From: Sarah Burrow <Sarah.Burrow@arun.gov.uk>
Sent: 11 June 2020 09:11
To: Planning.Responses <Planning.Responses@arun.gov.uk>
Cc: Maria Tomalova <Maria.Tomalova@arun.gov.uk>; 'Raymond Cooper' [REDACTED]
Subject: RE: Planning Consultation on: AL/37/20/DOC

Engineers Comments Regarding Surface Water Drainage

Application No:	AL/37/20/DOC
Registered:	4th May 2020
Site Address:	Forge House Nyton Road Westergate PO20 3UP
Grid Reference:	494185 105564
Description of Works:	Approval of details reserved by condition imposed under ref APP/C3810/W1/3213581 (AL/129/17/PL) relating to Condition No 3 - surface water drainage

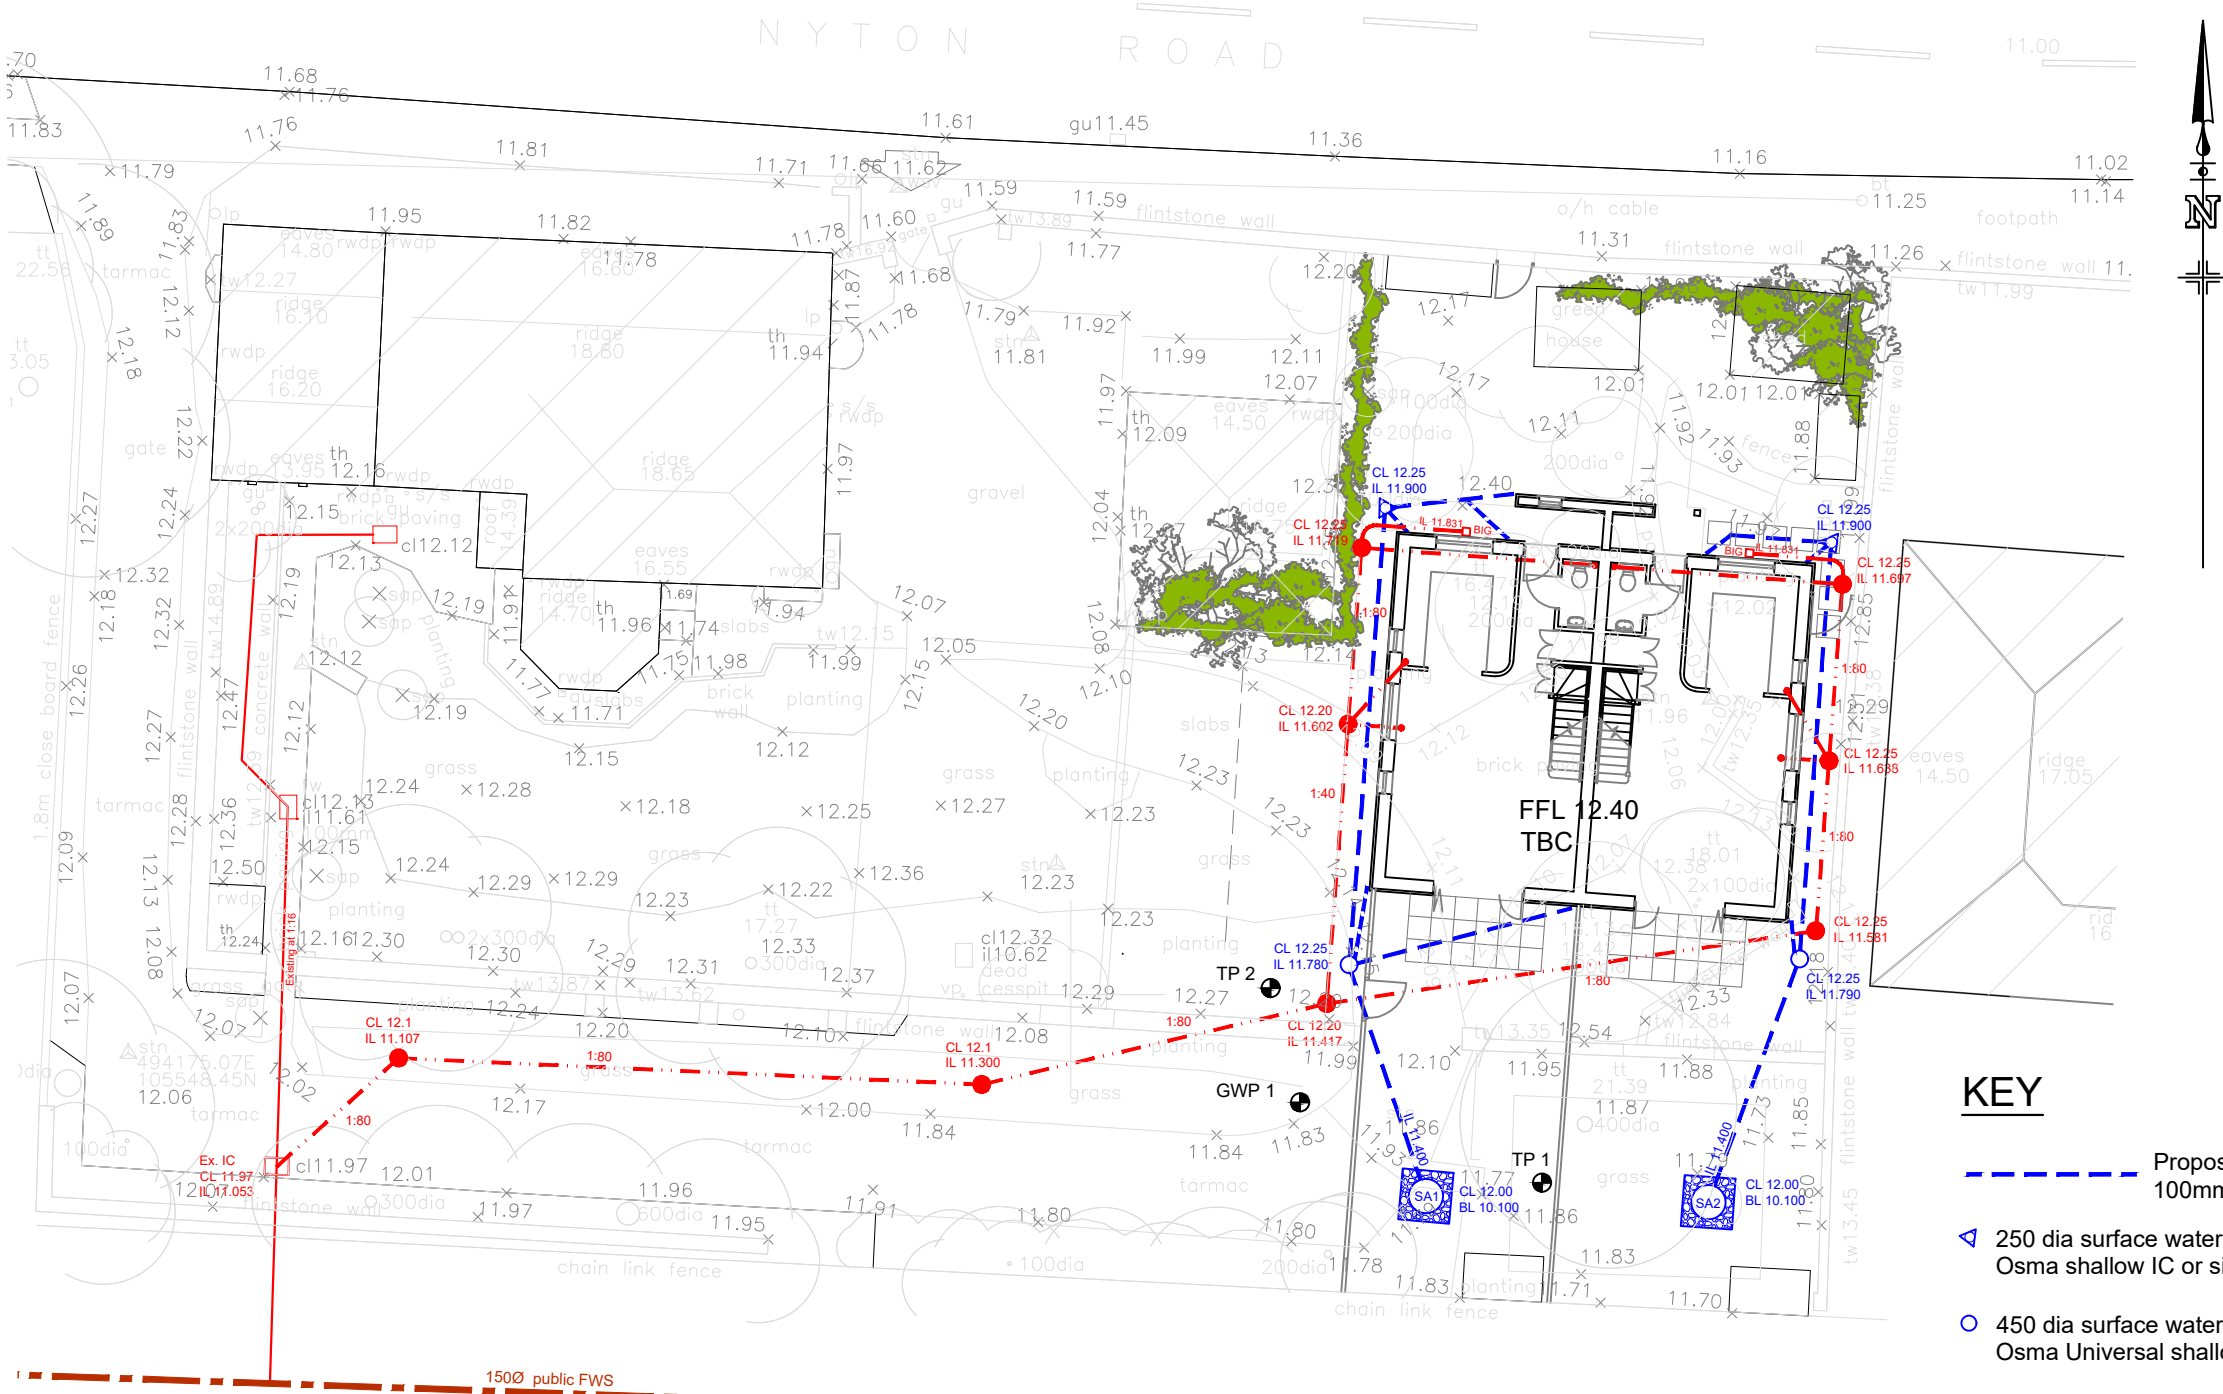
1. Please provide silt traps (or sumps on inspection chambers) upstream of the soakaways. Whilst it is acknowledged that the concrete ring soakaways are accessible for clearance, silt traps are easier to clear.
2. Please provide a construction detail for a concrete pipe bed and surround for where pipe depths are less than 900mm. Plus amend note as to when each surround should be used (Granular where cover to crown is greater than 1200mm in vehicular areas, or greater than 900mm elsewhere. For shallower depths concrete surround.)
3. Please provide a construction detail for the inspection chambers, and silt traps (see point 1).
4. Please confirm the dimensions of the trial pits within the Surface Water Drainage Notes.
